PLANNING BOARD REPORT PORTLAND, MAINE

Jewish Community Center and Preschool/Daycare 1342 Congress Street

Conditional Use & Level III Site Plan Review

Project # 2015-058

SITE PLAN

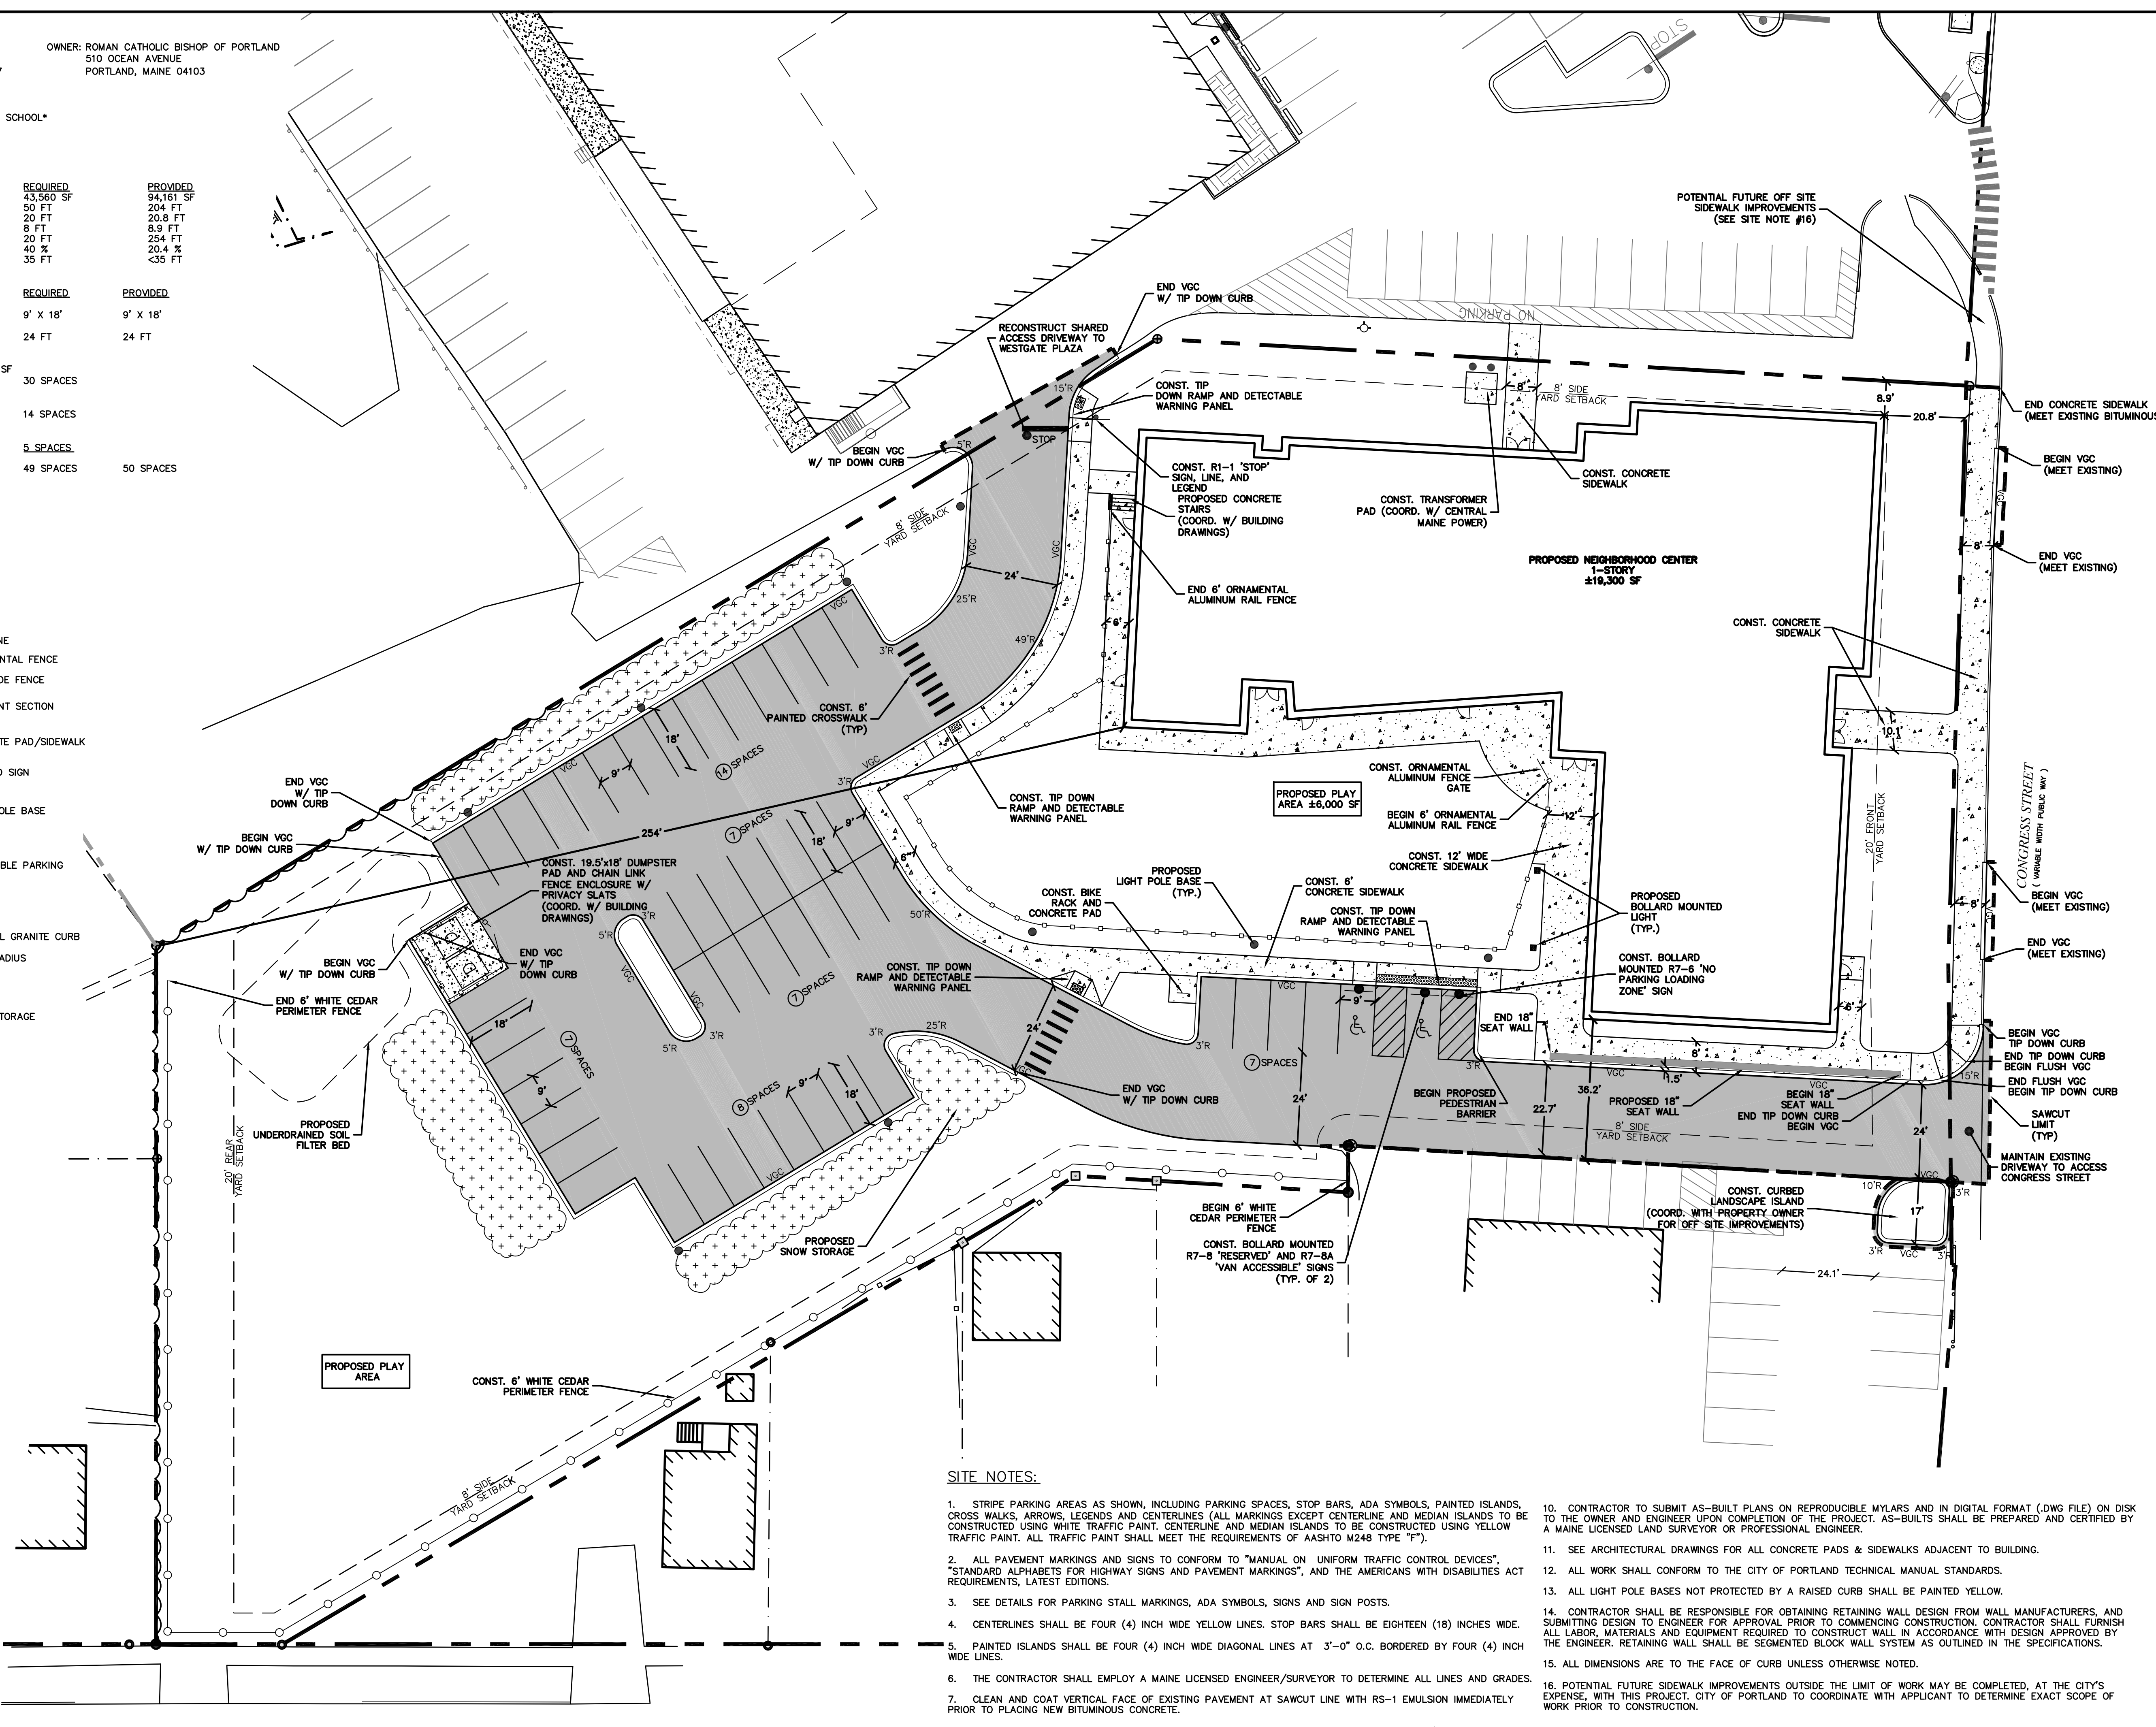
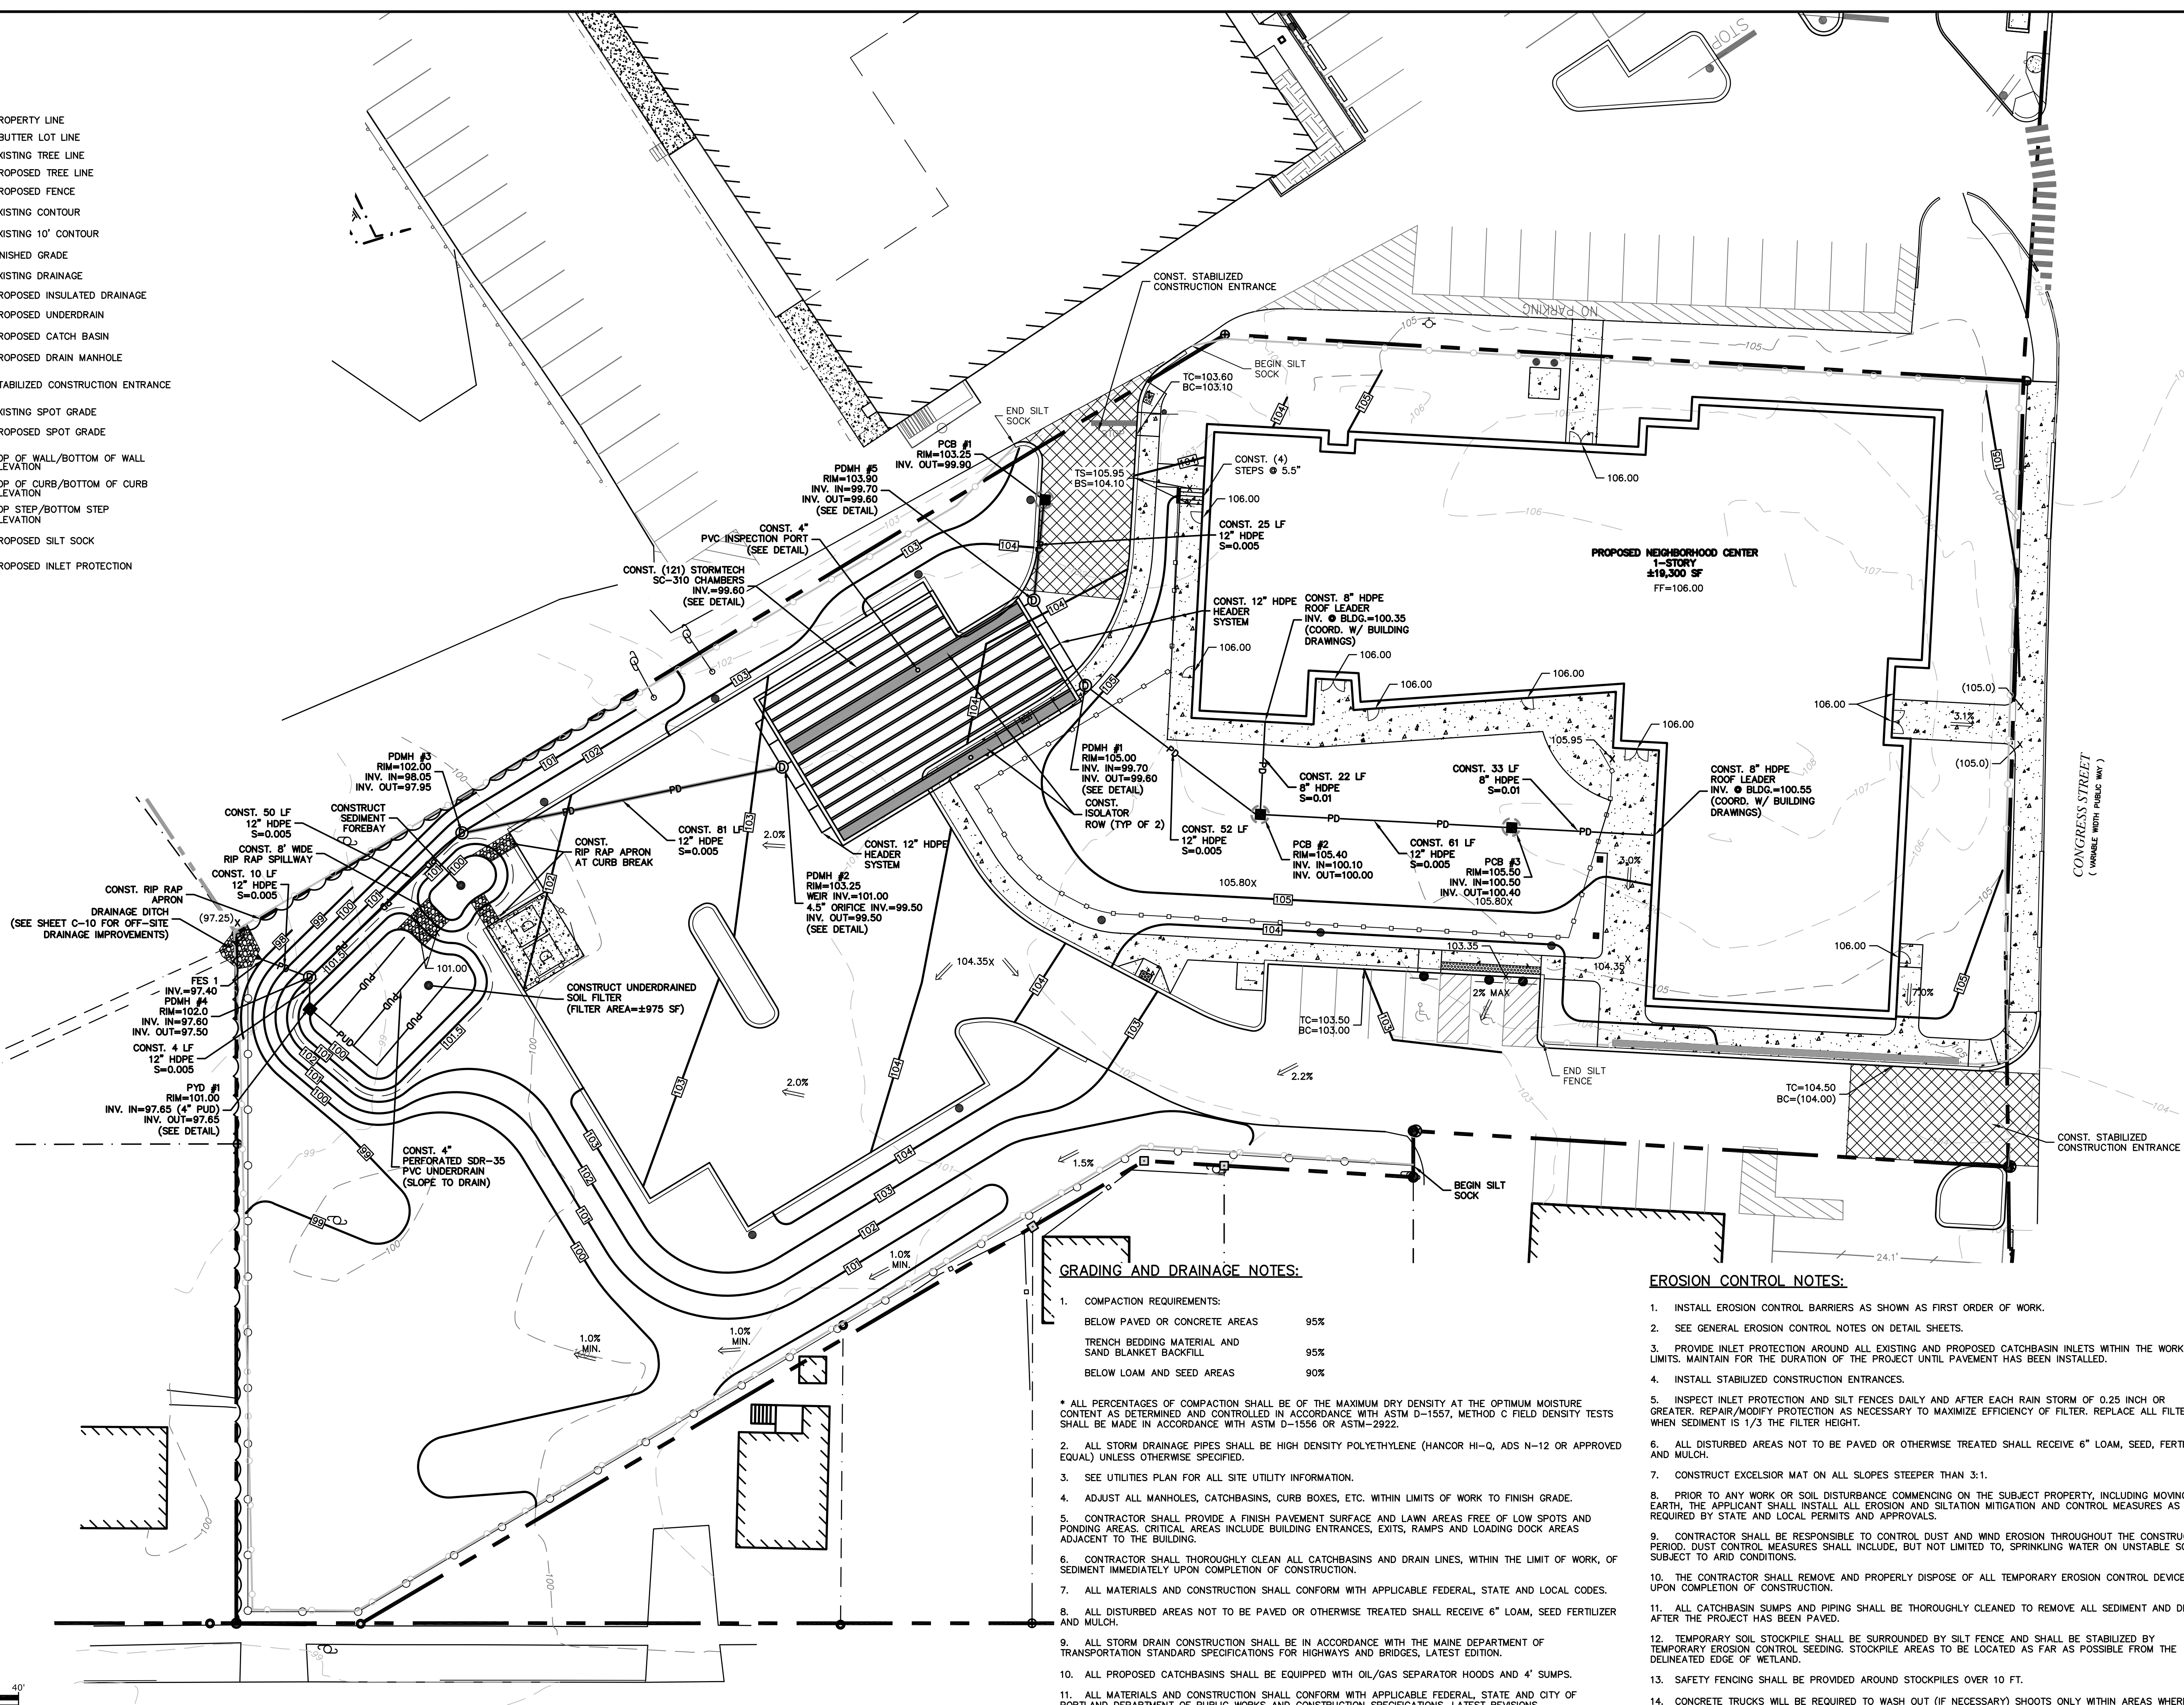
- *The driveway entering the site from Congress Street is noted as having a width of 22.7 feet. This width (in the area where parking maneuvers occur) does not meet City standards and thus a formal waiver should be requested by the applicant.*

- *The applicant shall consider the formal delineation of the driveway along the medical office property boundary, when entering from Congress Street.*

- *The pick-up and drop-off of daycare and others will need to be carefully managed. Accordingly, the applicant should provide specific details on how this process will take place. This should include what building entrances will be used, sidewalk facilities between parking spaces and the noted entrance, etc. I would note that the pick-up/drop-off program must be managed such that vehicles are not parking along the driveway off Congress Street.*

Status: I find the proposed driveway width to be acceptable given that most vehicles will be passenger cars and that a secondary driveway via the Westgate Shopping Center will be provided. I support this waiver request.

Status: The site plan has been revised and I find conditions to be acceptable.

Status: I have reviewed existing JCA activity at their current Portland site and I have recommended that a barrier be constructed that prevents pedestrians from accessing the building entrance near Congress Street. The applicant has revised the site plan to include a 18" sitting wall along the curb. While the height of the wall is mountable by pedestrians, I do believe the physical presence of the wall will deter drop-off and pick-up activity near Congress Street. Accordingly, I find conditions to be acceptable.
